SSD8606 - RESPONSE TO SUBMISSIONS - LOT 23 & 24 HOLLINSWORTH ROAD, MARSDEN PARK

This Response to Submissions (RtS) provides responses to the agency and community submissions received during the public exhibition of the Environmental Impact Statement (EIS) for a warehousing and distribution estate at Lot 23 and 24, Hollinsworth Road, Marsden Park (SSD 8606).

Drawing number :
MAP-SD-01

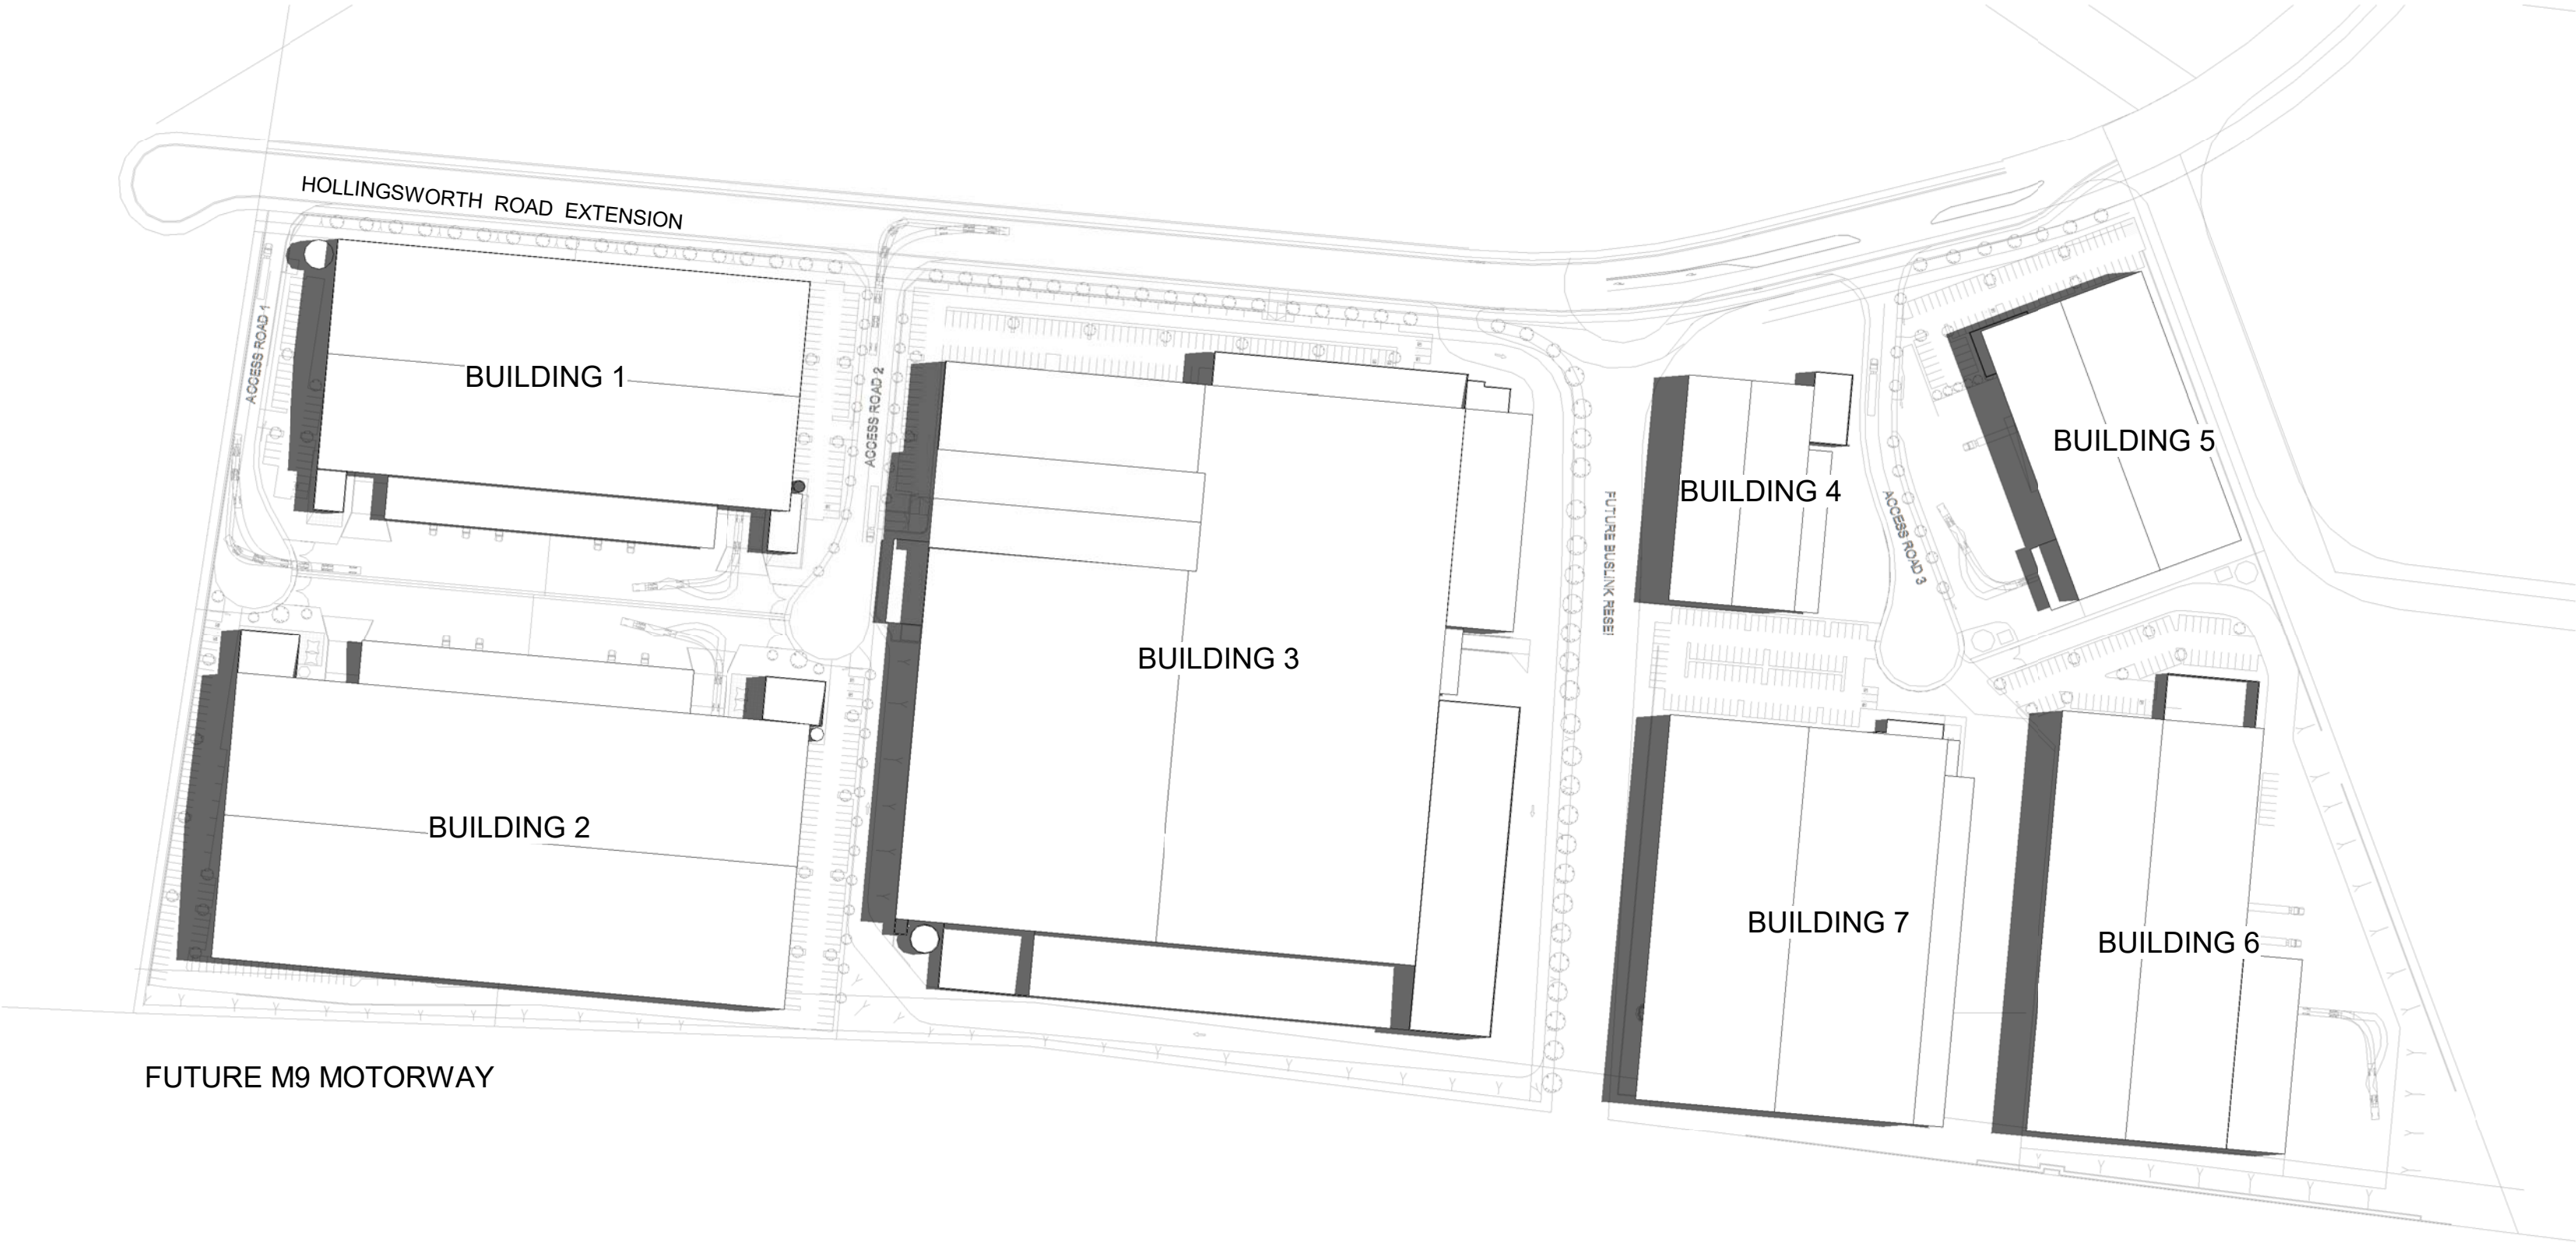
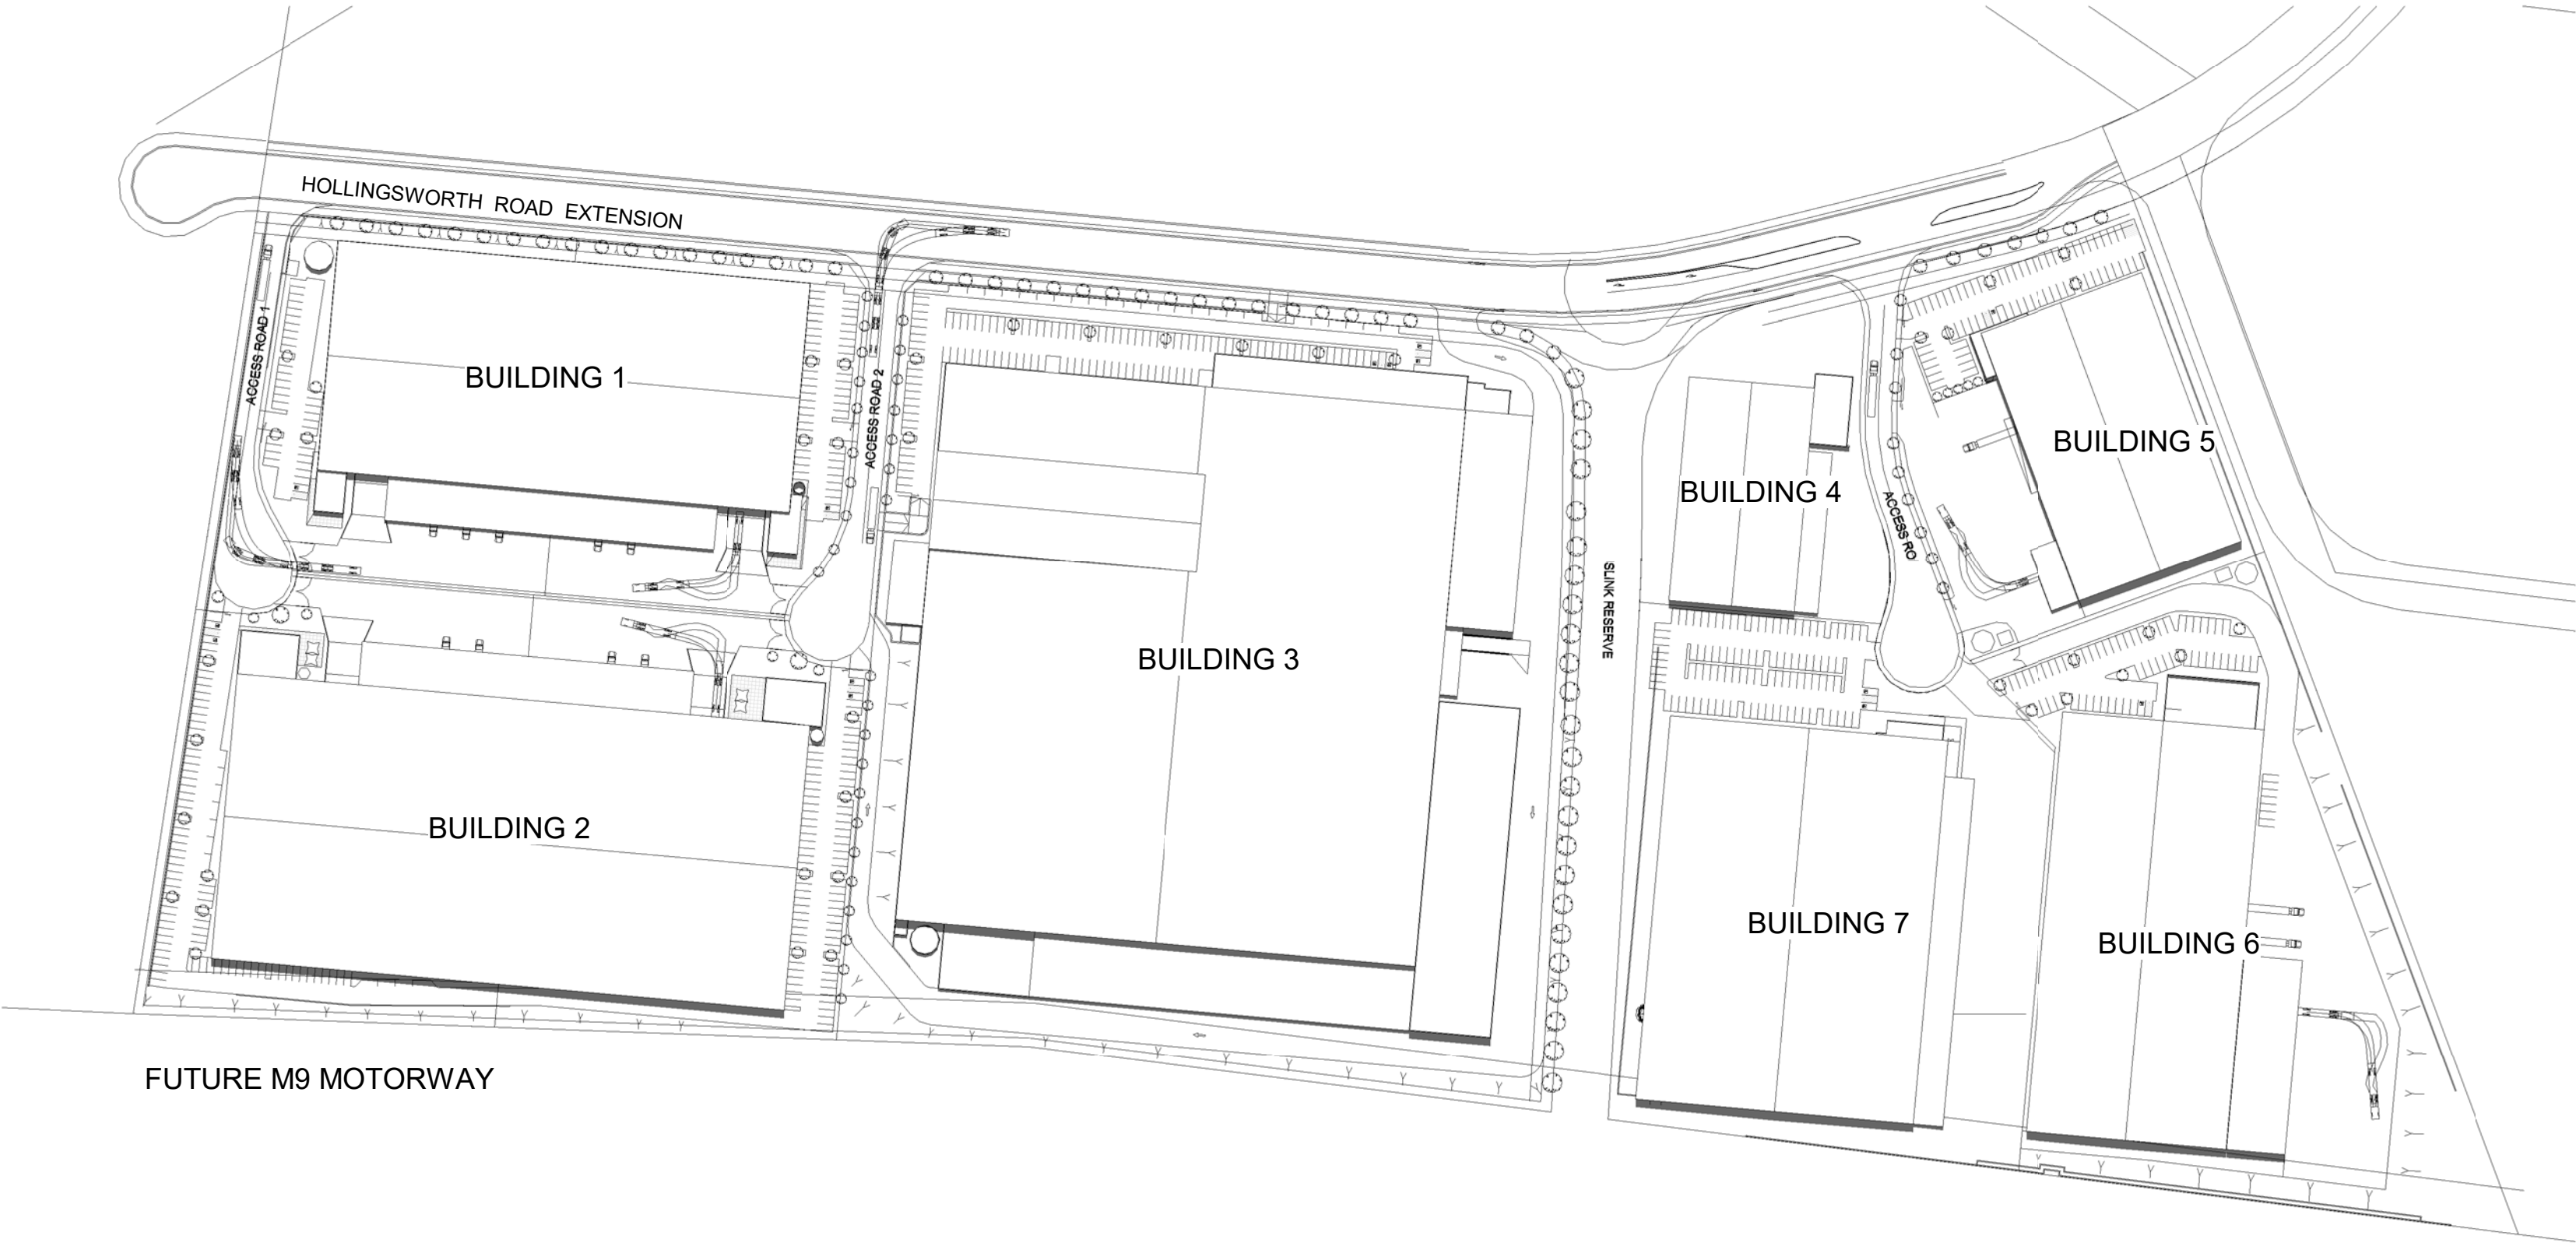
| Item Raised | Proponent's Response |
|-------------------------------------------------------------------------------------------------------------------------------------------------------------------------------------------------------------------|---------------------------------------------------------------------------------------------------------------------------------------------------------------------------------------------------------------------------------------------------------------------------------------------------------------------------------------------------------------------------------------------------------------|
| A shadow diagram should be provided. | Shadow diagrams have been prepared to show shadows at 9am, 12pm and 3pm on 21 December and 21 June. |

| Item Raised | Proponent's Response |
|--------------------------------------------------------------------------------------------------------------------------------------------------------------------------------------------------------------------------------------------------|--------------------------------------------------------------------------------------------------------------------------------------------------------------------------------------------------------------------------------------------------------------|
| | <p>No detrimental shadow impact is generated by the proposal, given the separation distances between the site and the public domain / residential receivers.</p> <p>Refer to drawings LG-MAR-S1 and LG-MAR-S2.</p> |
